Department of Transportation

US-024G and Stapleton Road
El Paso County

January 27, 2025

• Report Comments

**WATERBURY EAST CHANNEL PLAN & PROFILE VIEW**  
 HORZ SCALE: 1"=100' - VERT SCALE: 1"=10'

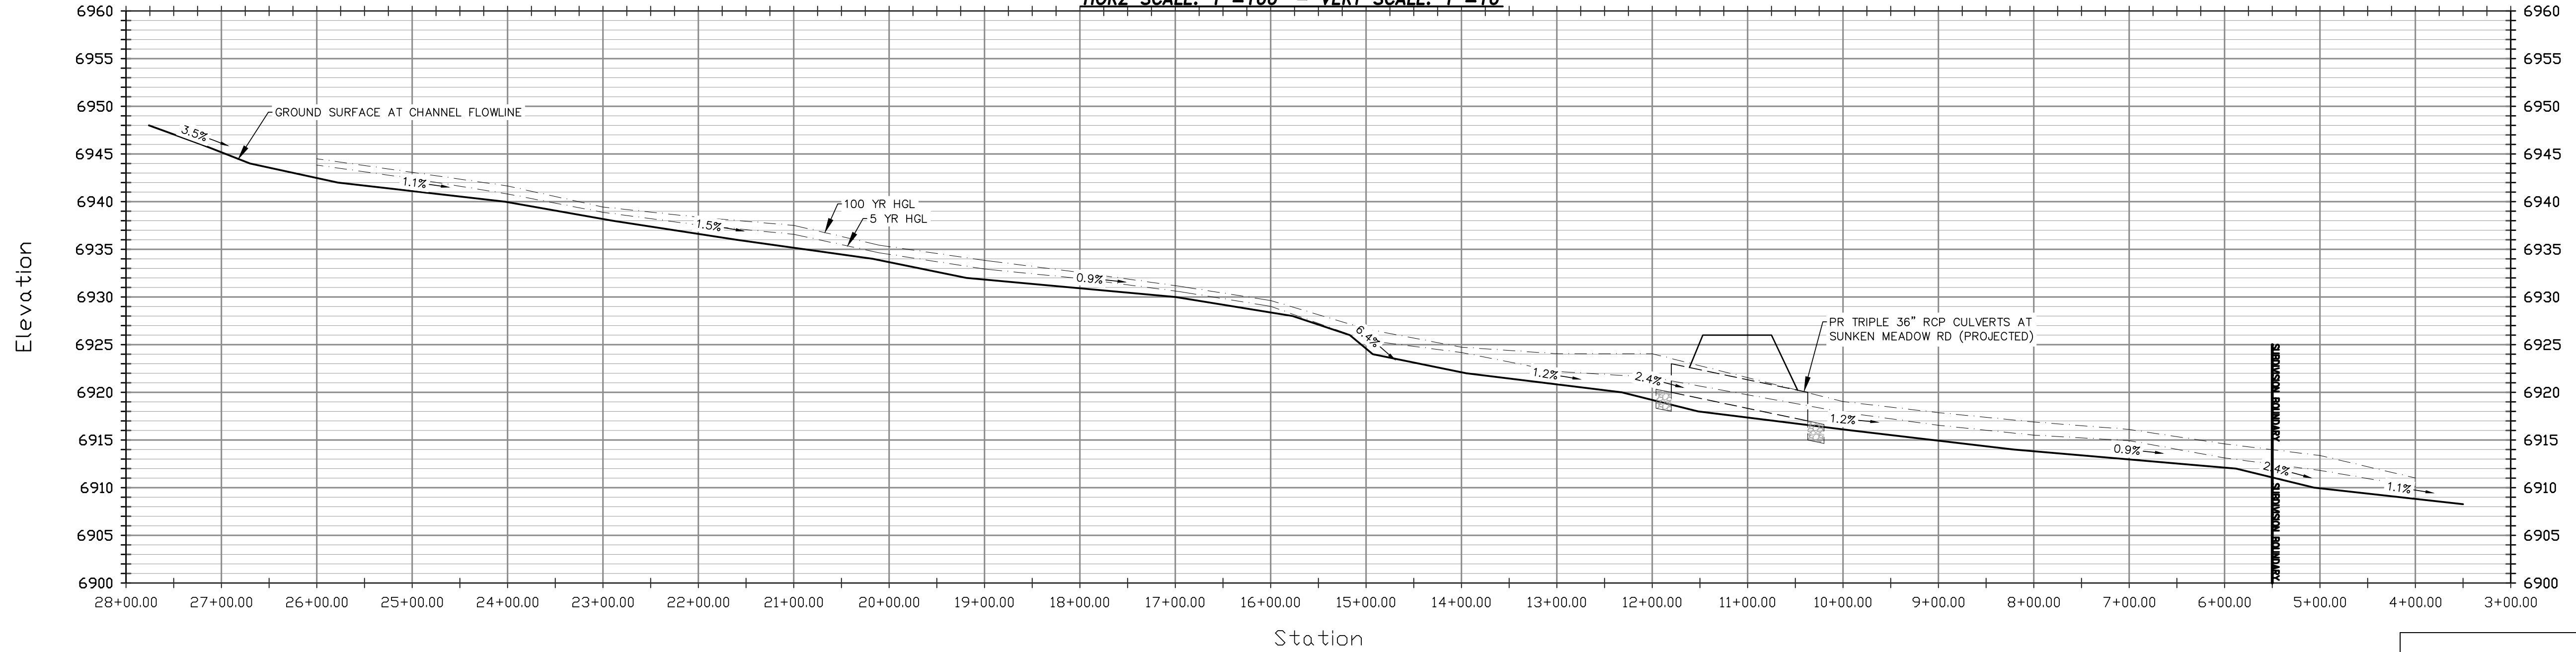
- **Repeat comment:** The HEC-RAS model does not appear to account for the pond scenarios (100% of 100-year flows passing through emergency overflow). Potential downstream impacts of the proposed ponds to CDOT facilities are unclear.
 - A peak flow of 188 cfs was used for the East channel analysis. The peak flow is 188 cfs, and the peak outfall in the 100-yr event is 37 cfs. If the spillway is releasing water, an additional 200 cfs will be realized into the channel directly upstream of CDOT facilities.
 - Do the channel and the US24 culvert have capacity for this scenario?

Yes, the eastern channel has capacity. Added sentence in report and appendix has x-Sections showing the flow in the channel and also the culvert passing the flow.
